Mallard Pass Solar Farm

**Applicant's Response to
Interested Parties' Deadline 2
Submissions - Air Quality,
Noise, Vibration and Health**

EN010127/APP/9.17

Figure 10.5.6 – Noise predictions with SAT central inverter arrangement, including receptor locations (black/white dots) and PRow (black lines)

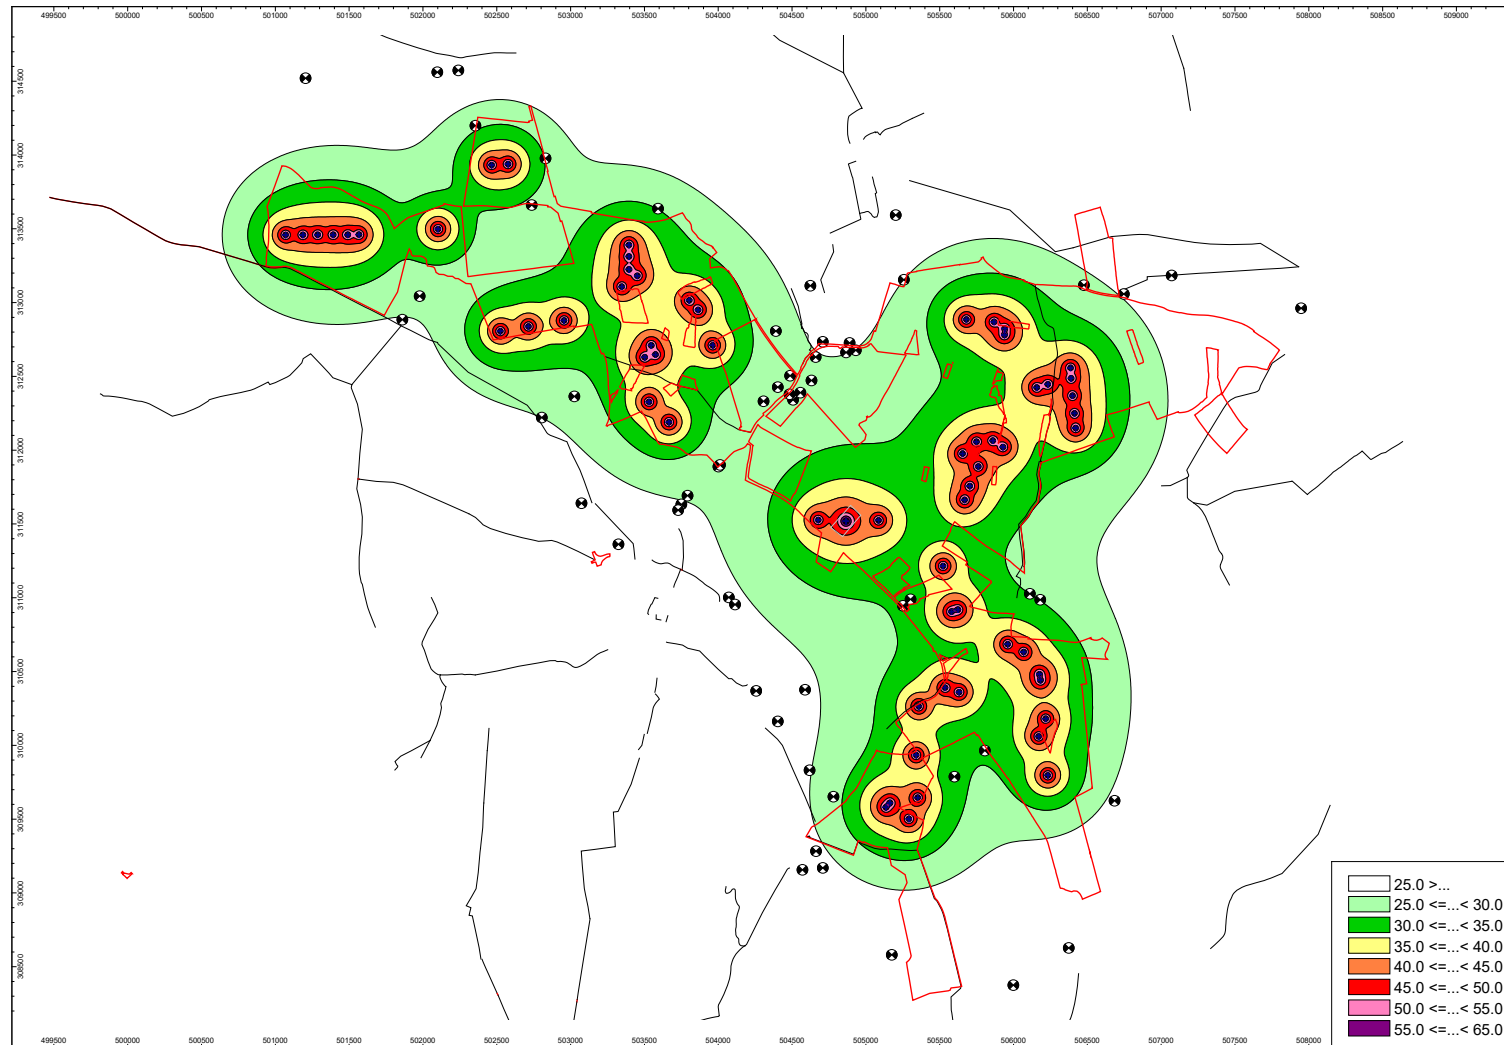
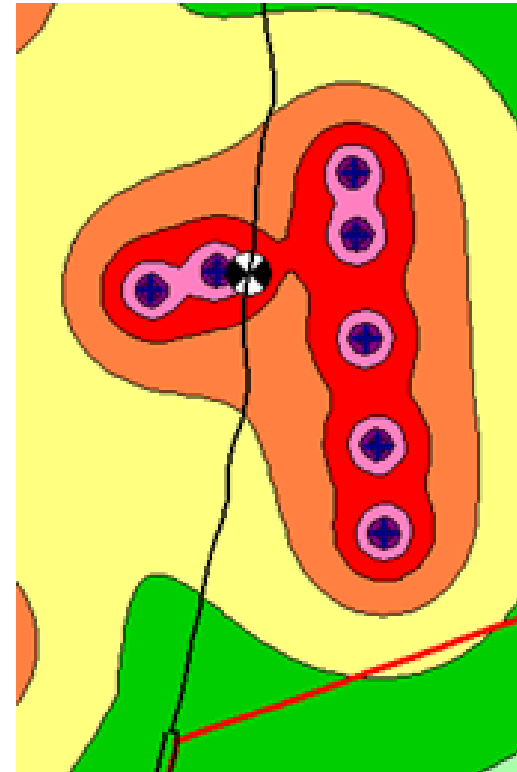
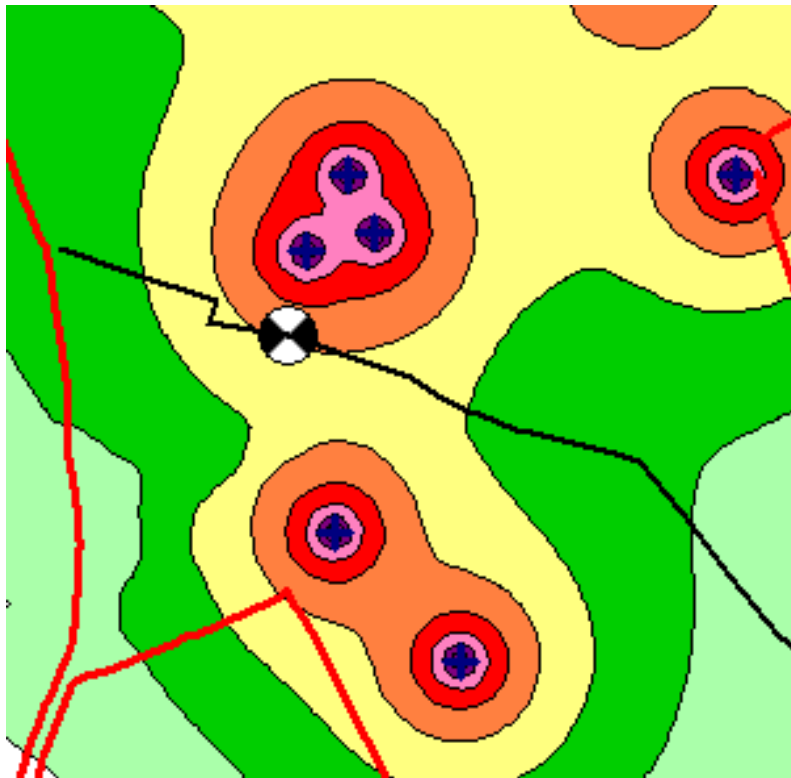
<p>PRoW receptors are at least 50m from any central inverters and are located more than 800m from the On-site substation. The modeling results of Appendix 10.5 shows that operational noise levels would not exceed 50 dB Laeq, which is therefore clearly below a precautionary level. Making comments in relation to the precautionary level and concluding that PRoW are of medium sensitivity to noise and vibration, because users are</p>	<p>The basis for the assessment of PRoW receptors was set out in detail in Appendix 10.1 [APP-077] and Appendix 10.2 of the ES [APP-078], and was further clarified in the response to Q9.0.1 in the Applicant's Response to ExA's First Written Questions (ExQ1) [REP2-037].</p> <p>For the assessment of construction and decommission effects, the PRoW receptors were considered as having medium sensitivity to noise or vibration, which is similar to what would be considered for public amenity areas such as parks, but the PRoW are used on a more transient basis, so exposure to noise from the Onsite Substation and any Solar Stations would be transient and comparable to exposure to localised sources of noise for other portions of the PRoWs (including traffic noise and agricultural activities).</p>
